SECTION 4.55(1A) APPLICATION TO AMEND SSD_9343 – MEADOWBANK SCHOOL

This letter has been prepared on behalf of NSW Department of Education (DoE) and School Infrastructure NSW (**the Proponent**) in support of a Section 4.55(1A) application to modify SSD_9343 in relation to Meadowbank Education and Employment Precinct Schools Project, at 2 Rhodes Street, Meadowbank (Lot 10 123584).

LEVEL 3 FLOOR PLAN

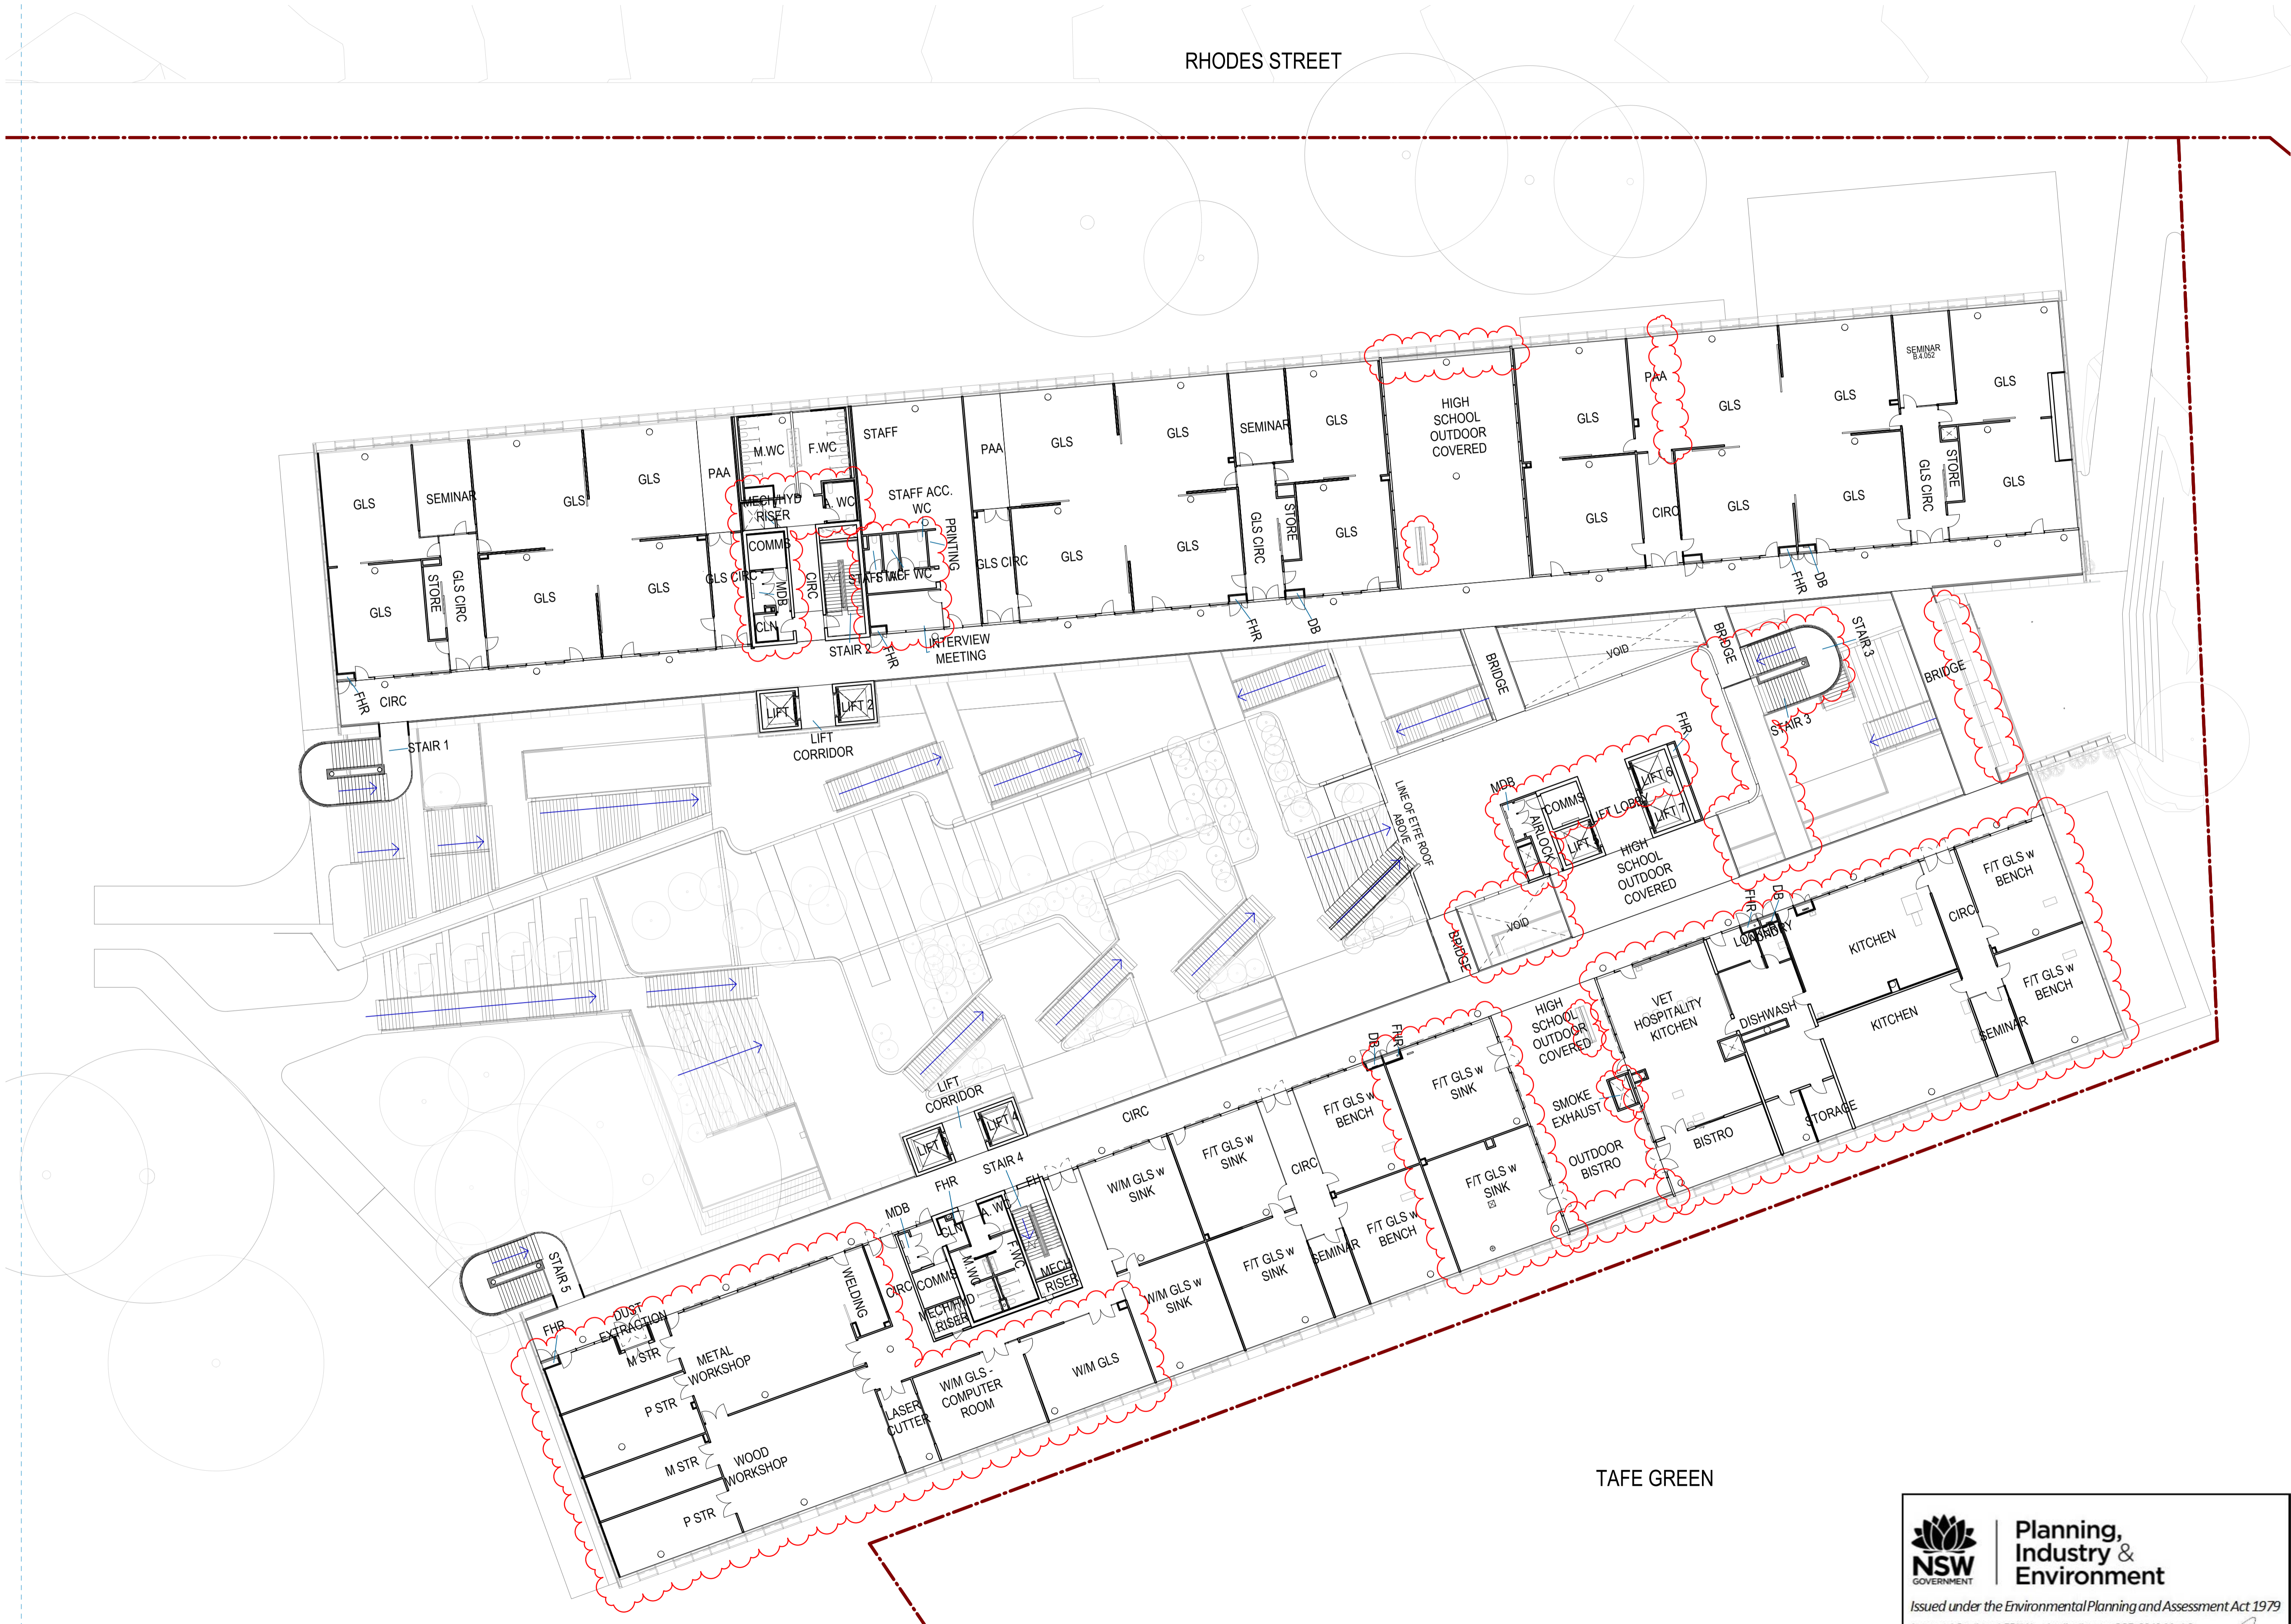
- Planters removed to all COLA façade edges of primary school and high school.
- Amendments and additions of voids.
- Stair layout and planter extent amended.

DRAWING TITLE
**PLAYGROUND - PART 2
FINISHES PLAN**

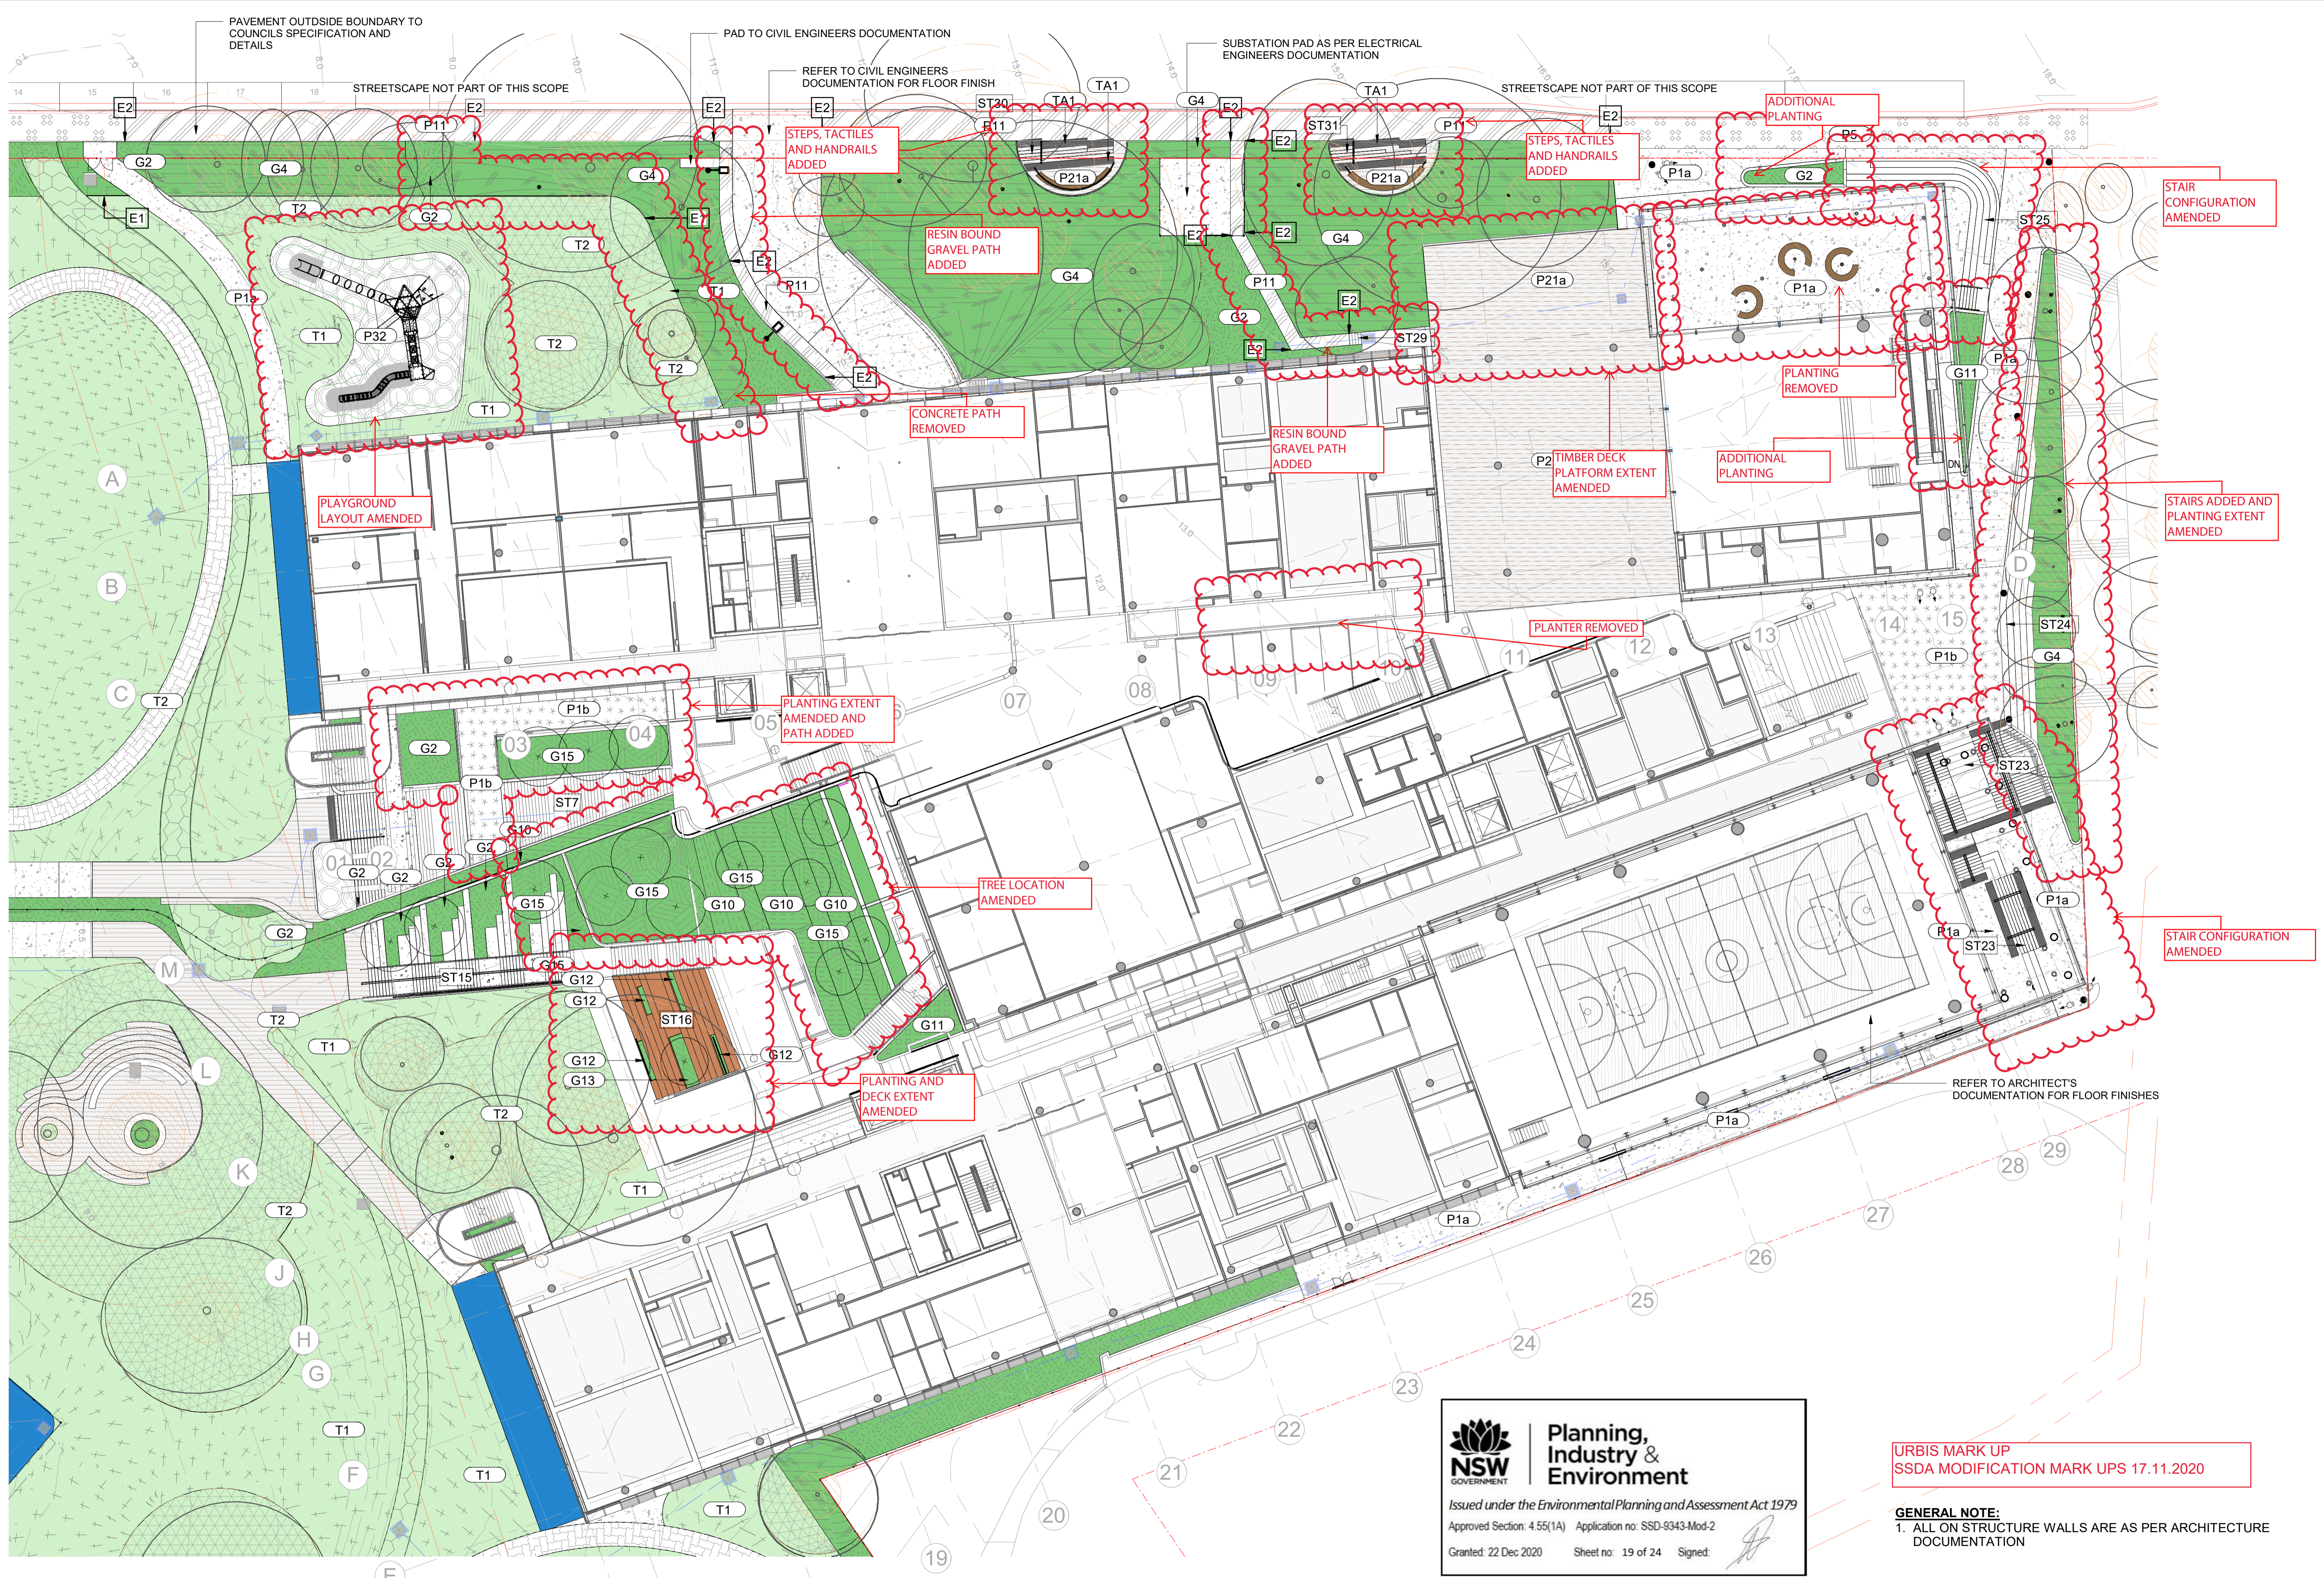
- Rearrangement of fire stairs which no longer extend to playground.
- Minor amendments to landscaping, including:
 - Line marking of sports courts.
 - Amphitheatre and seating steps redesigned
 - Relocation of shed on western side of sports courts.
 - Veggie patch reconfigured and turf type amended.
 - Bound gravel replaced with garden bed and turf.
 - Additional path adjacent to stairs.
